Application H14-0532-26
Location Land off Bervor Close Pinchbeck Spalding PE11 3ZN
Proposal Construction of BIO-LNG Refuelling Station

Name National Grid Electricity Distribution
Address formerly Western Power Distribution

Date Submitted 28-06-26
For/Against Comments

Drawing Title: LNG DP STATION SITE/BLOCK AND LOCATION
PLANS
Scale: 1:250 and 1:2500
Date: MARCH 26
Drawn: DB
Checked: D

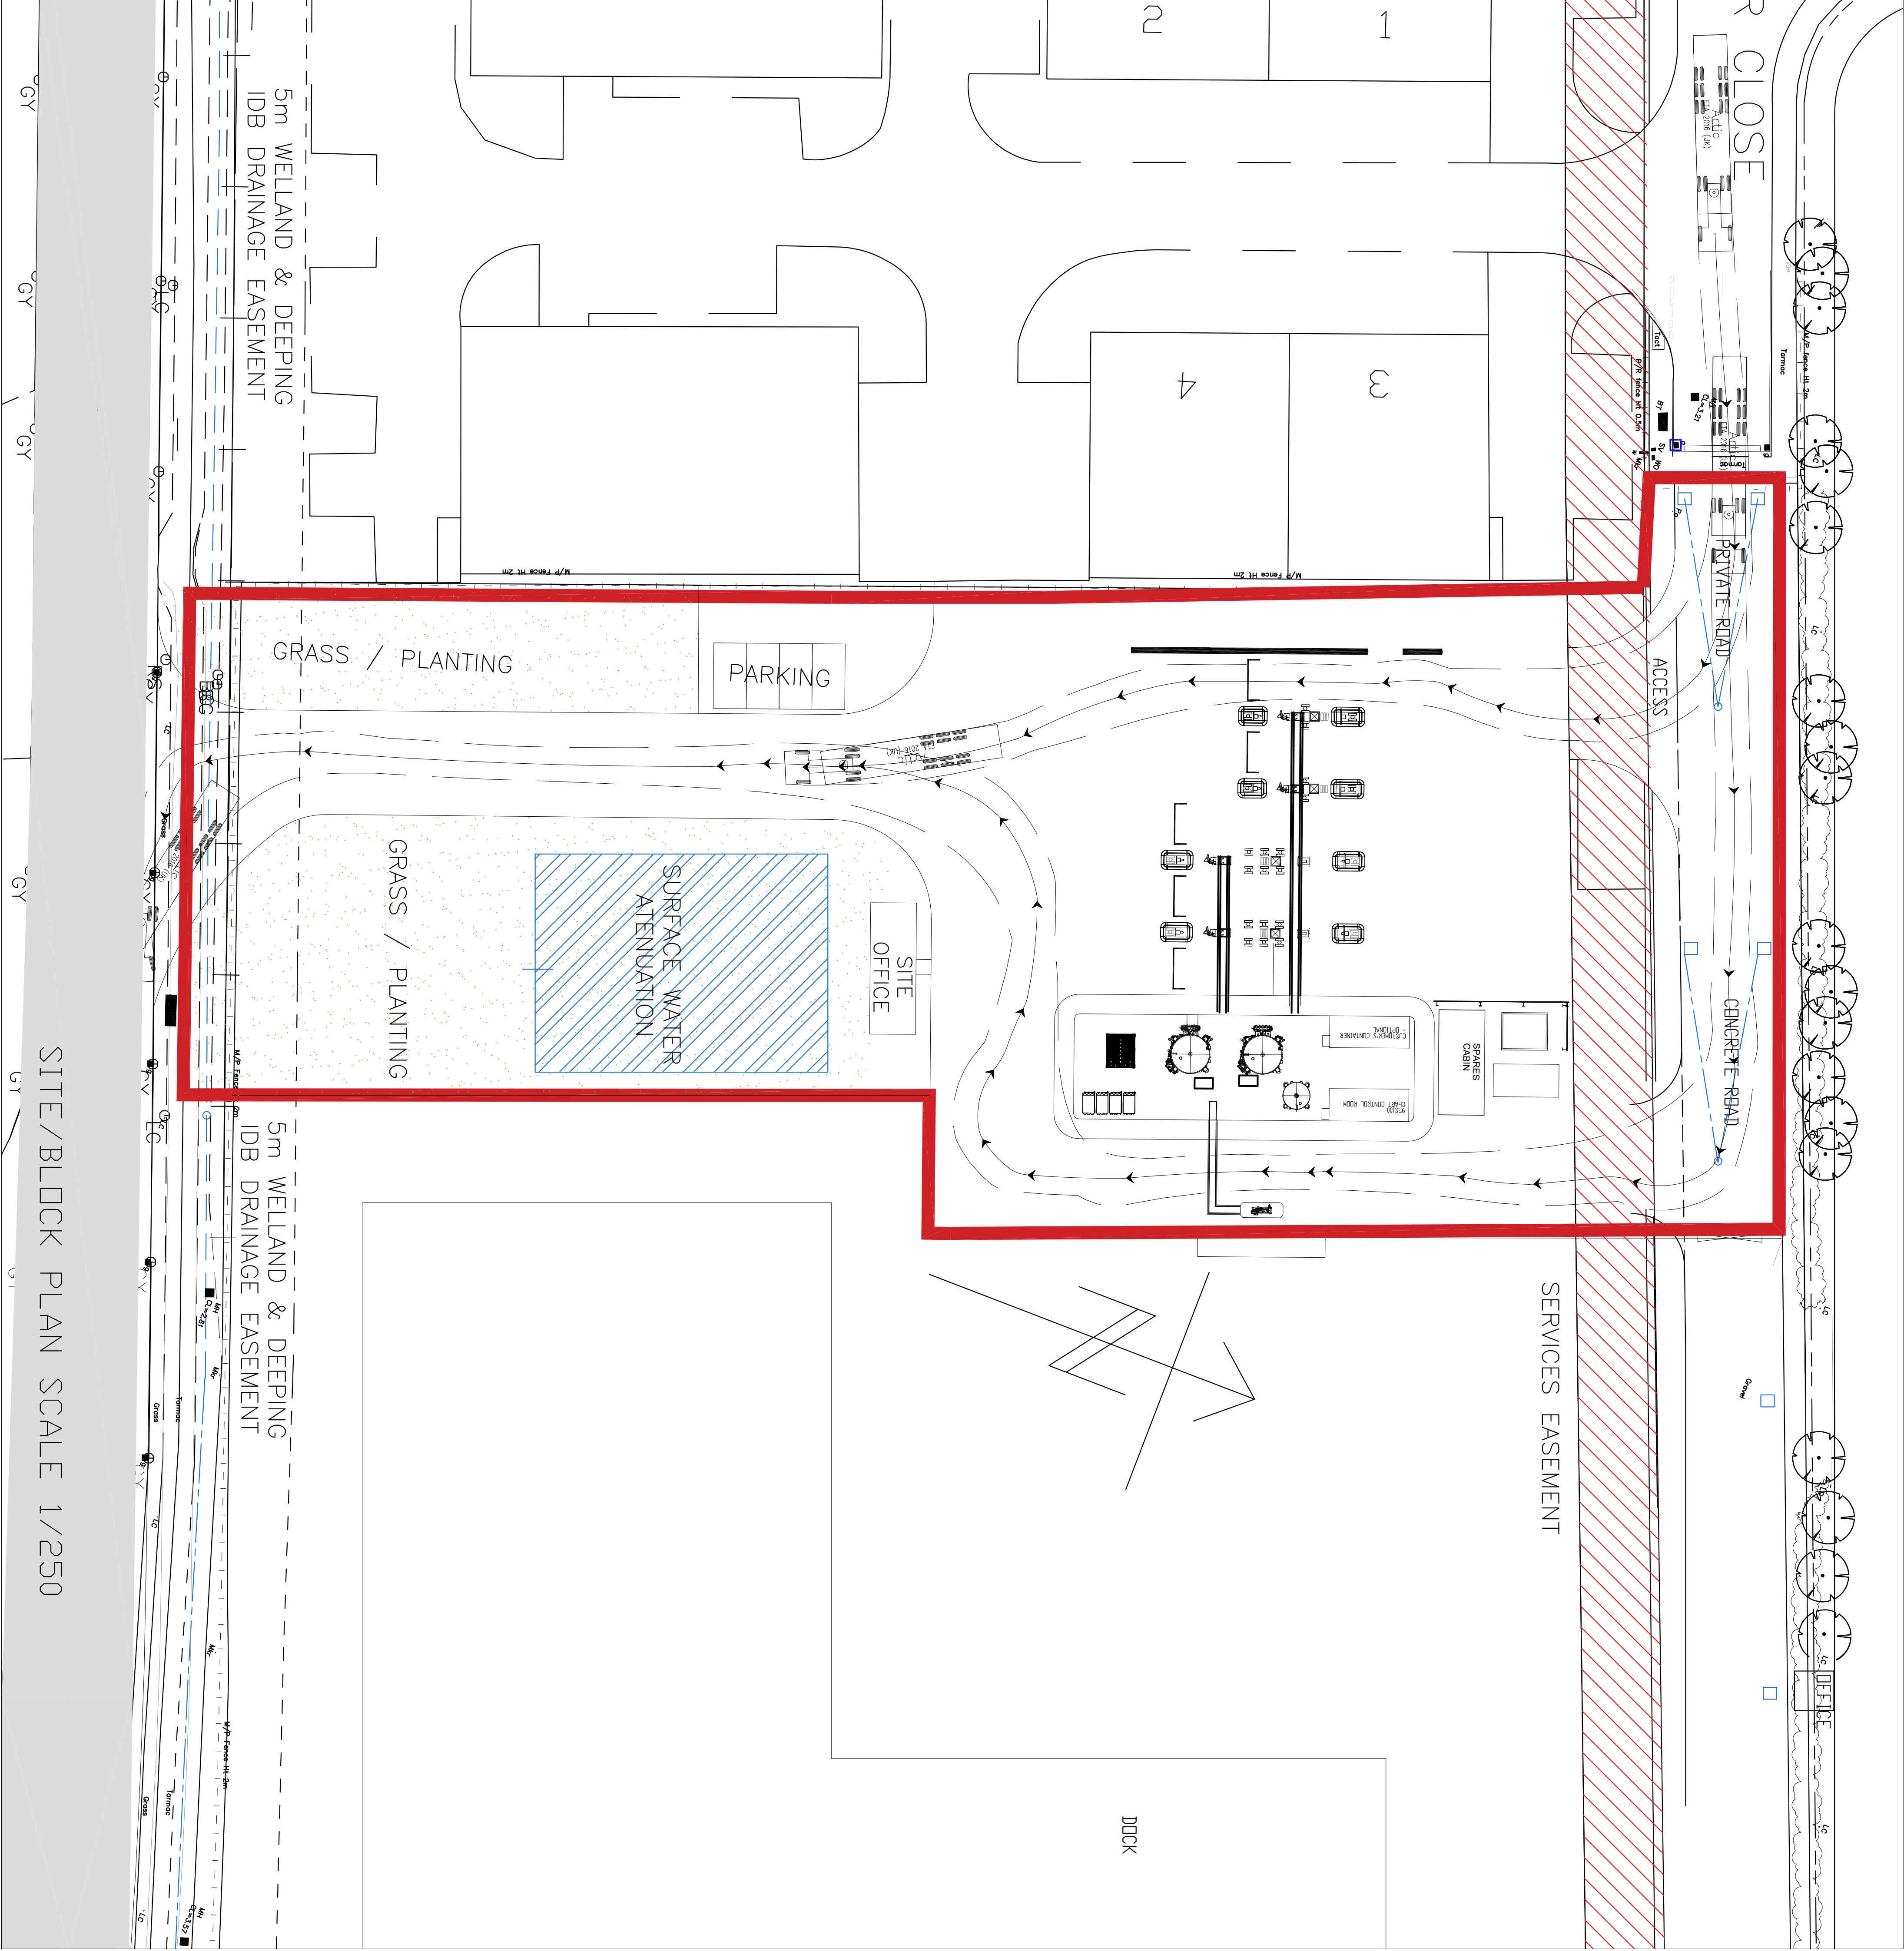
Please note there is 11kv UG cable at the front of the land boundary (roadside), there is also some 11kv and 33kv UG near the private road at the rear, please contact NGED if you require any advise
